CITY OF ALBUQUERQUE

June 9, 2022

**RE: Lot 2 Executive Hills 2
700 Winterwood Pl. SE
Grading and Drainage Plan - Approved
Engineers Stamp Date 6/6/22
File Number (L23D038)**

GRADING PLAN

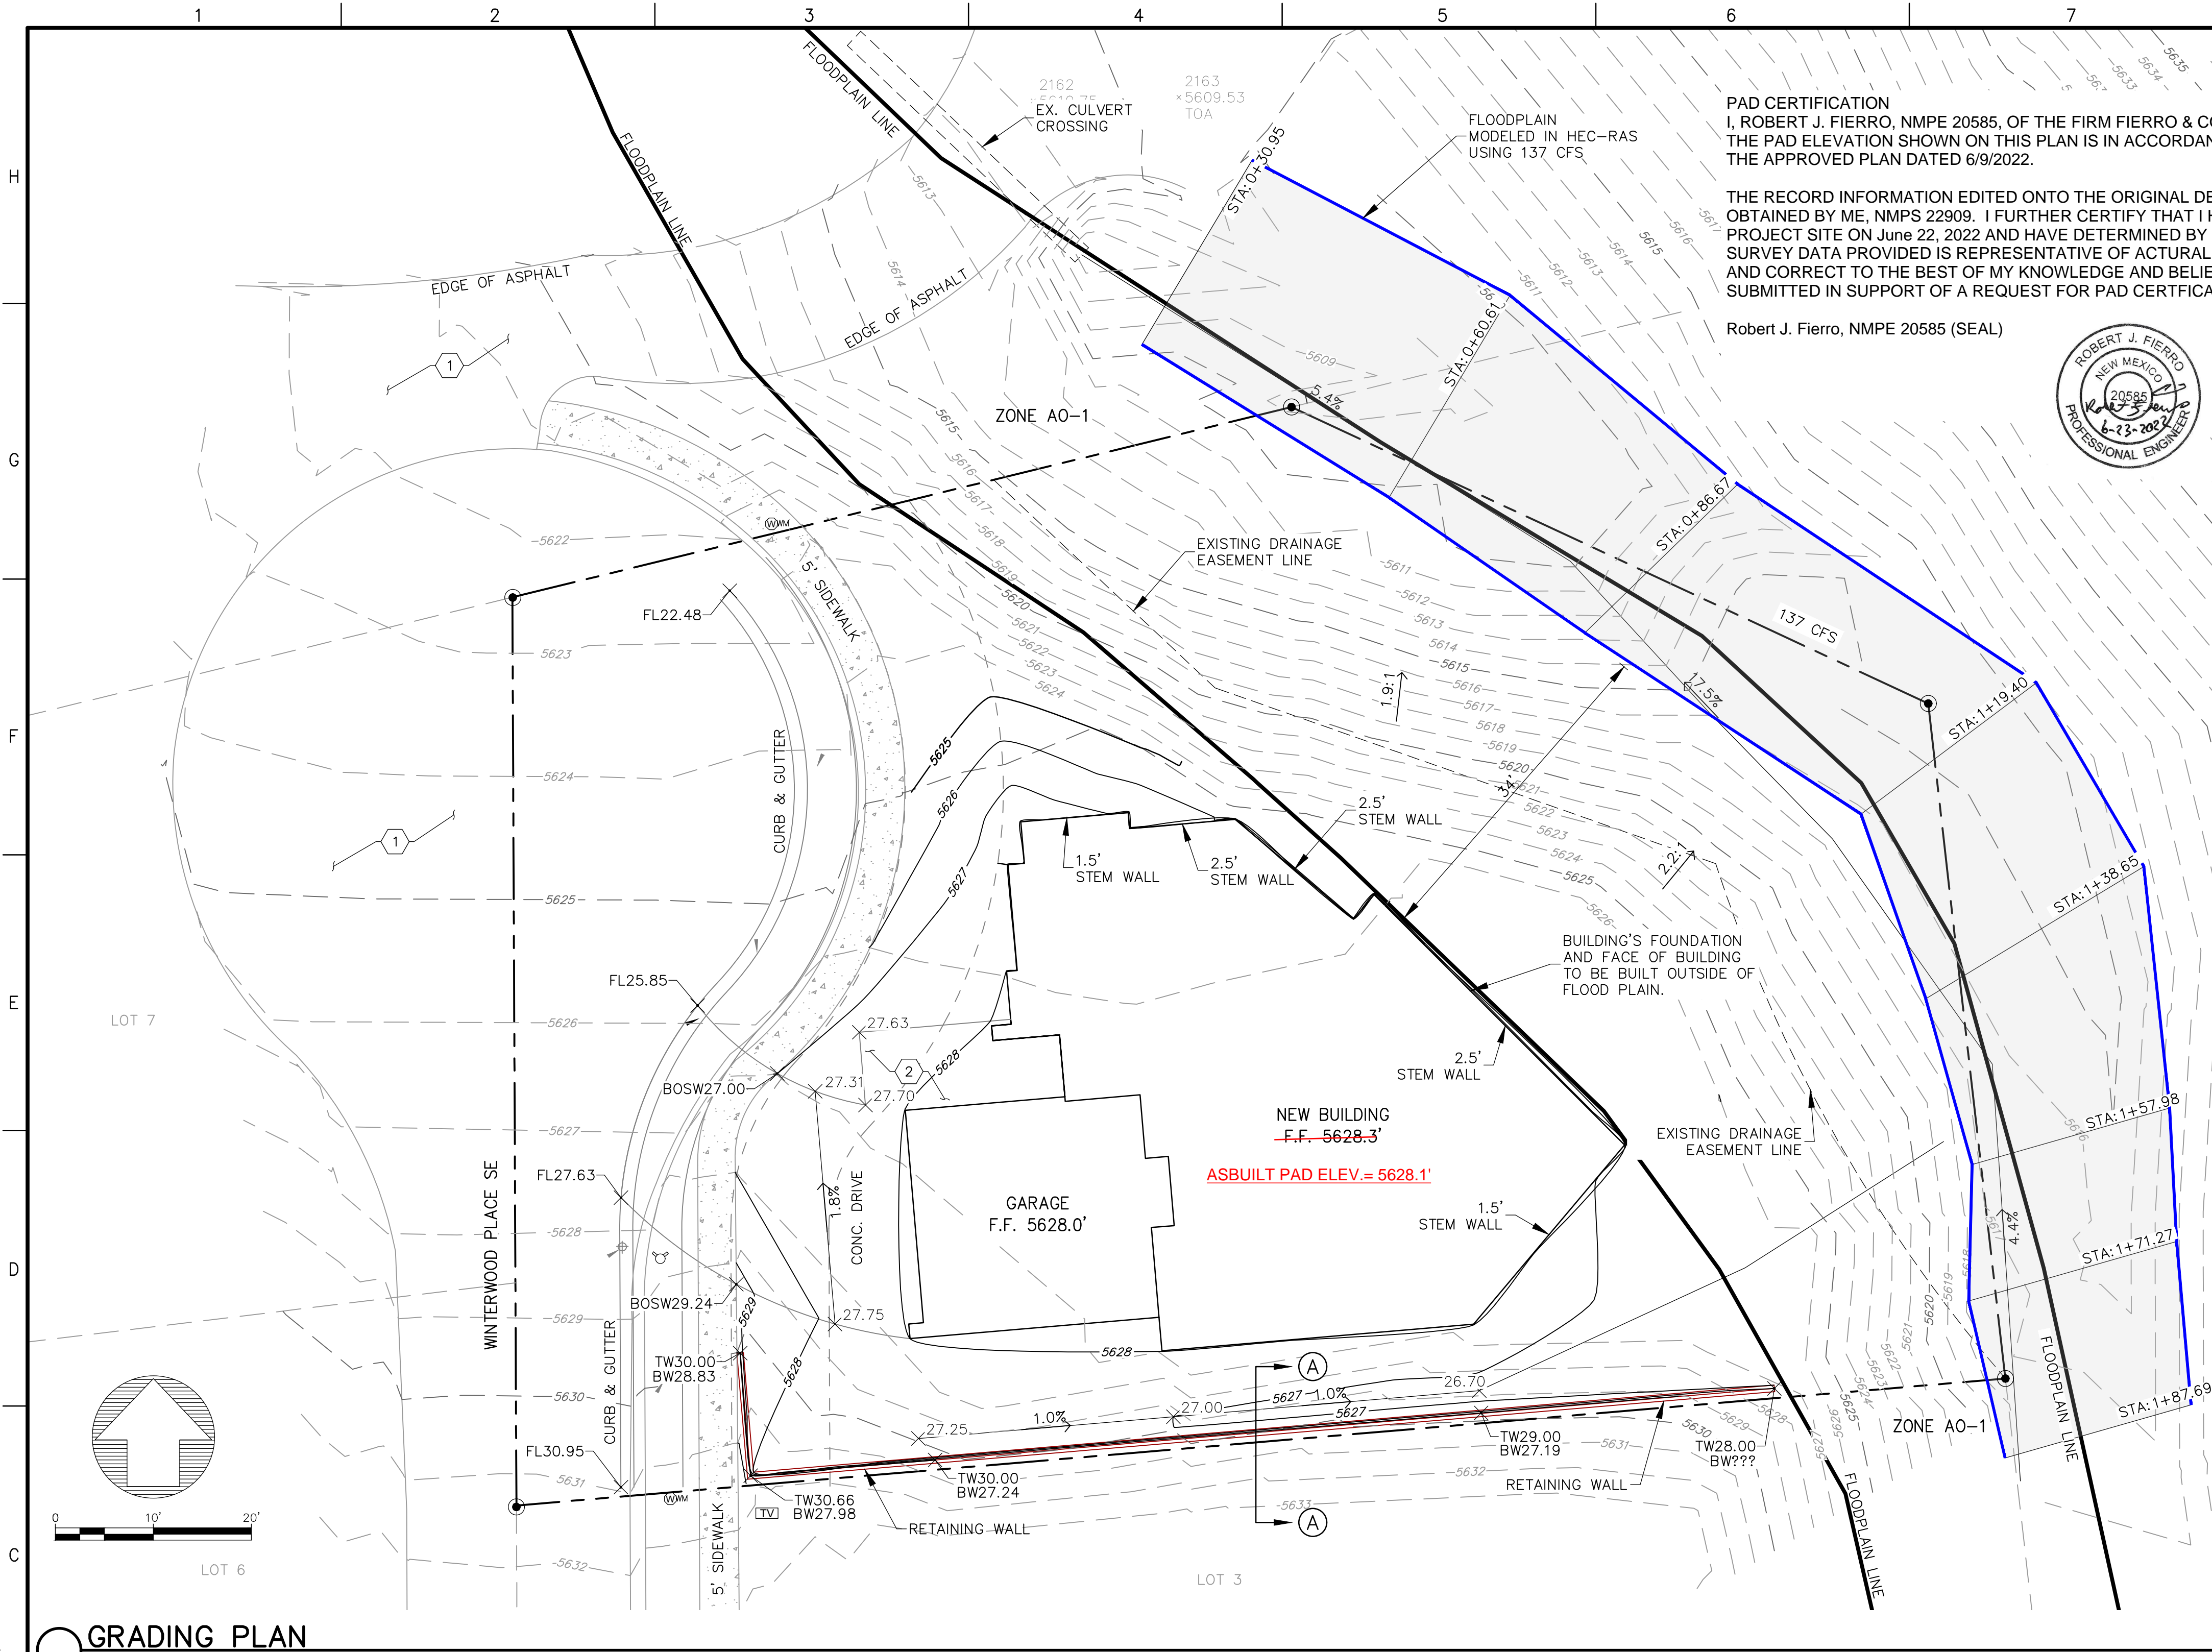
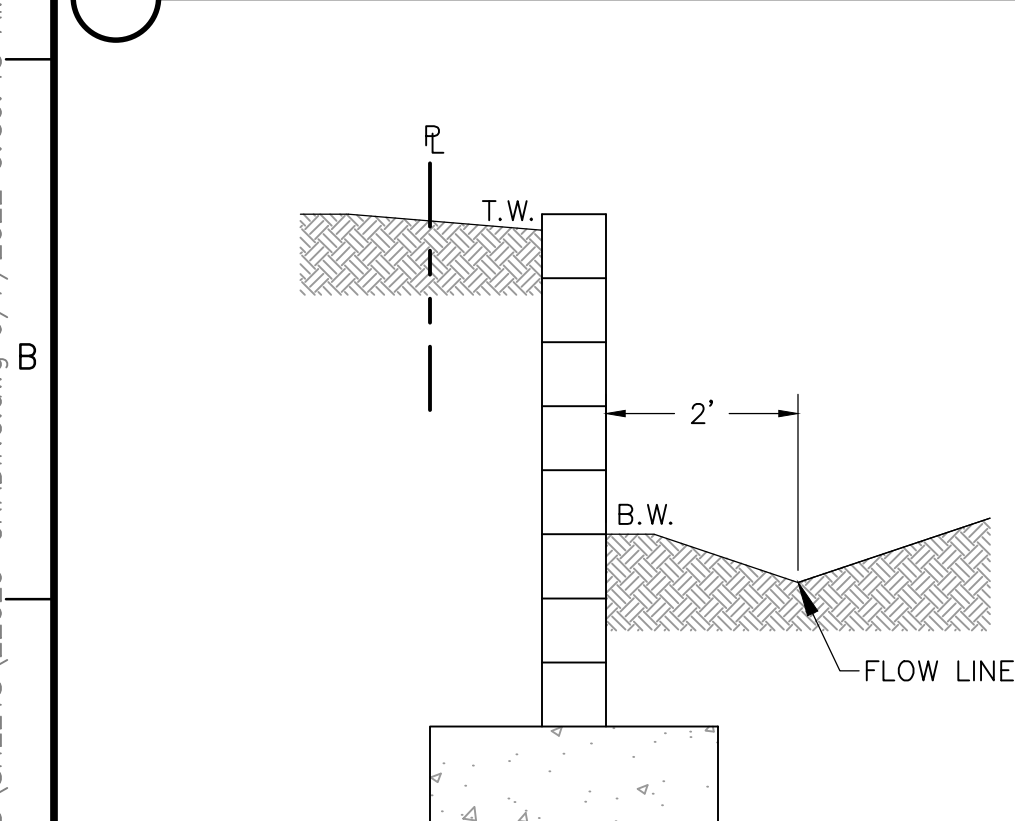
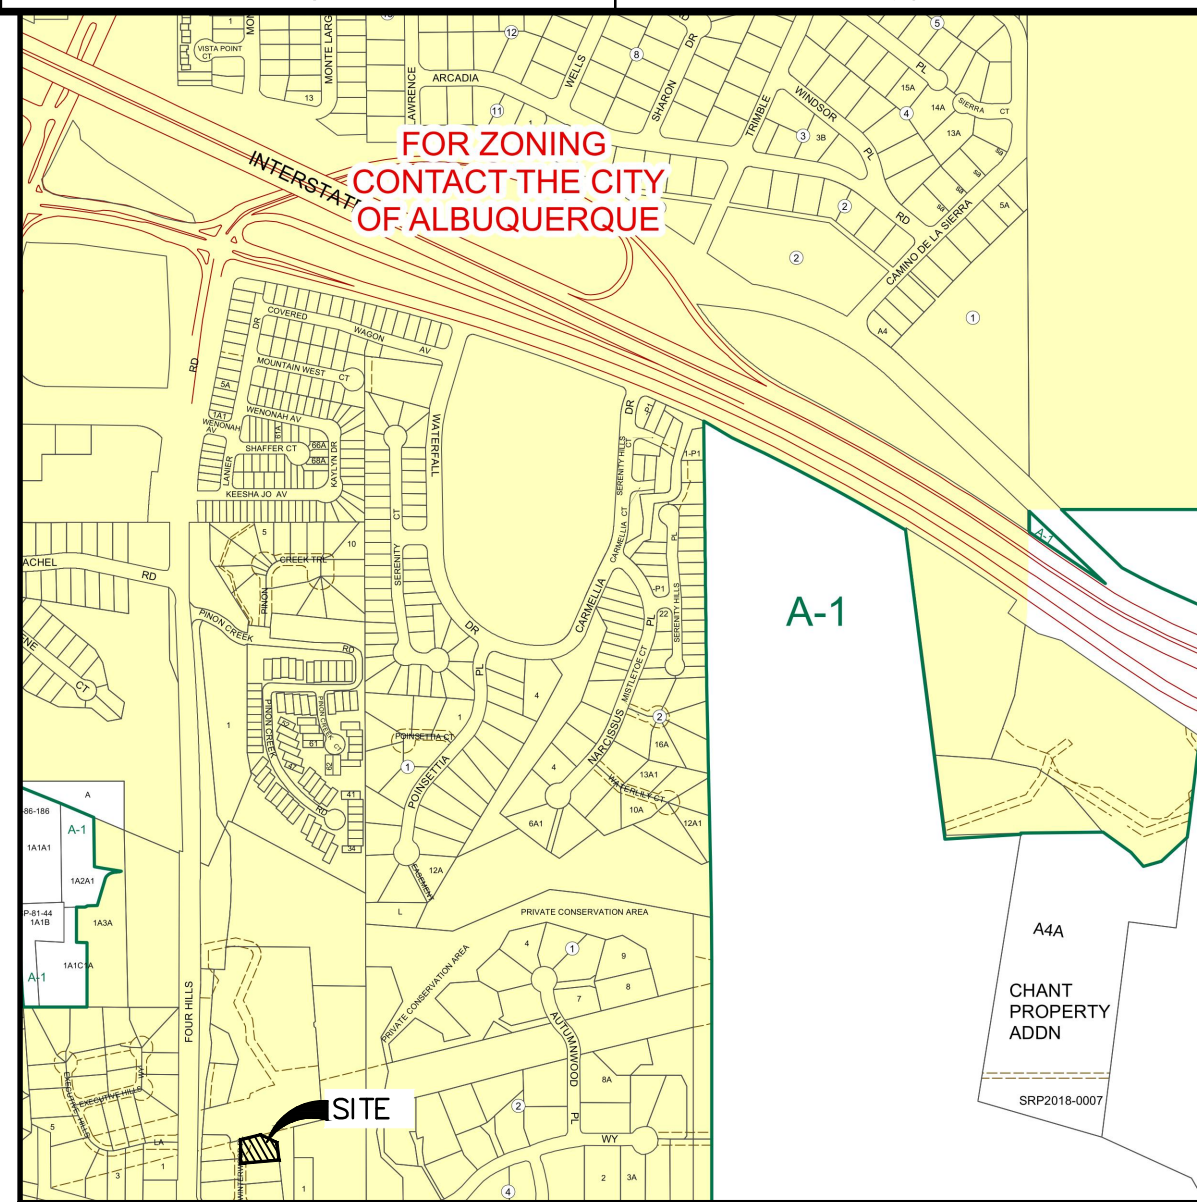
Please place a Drainage Easement over the arroyo to ensure this does not get filled in the future. This can take place at a later date so long as it occurs prior to CO. A final (as-built) elevation certificate must be submitted and approved by Hydrology prior to issuing approval for Certificate of Occupancy.
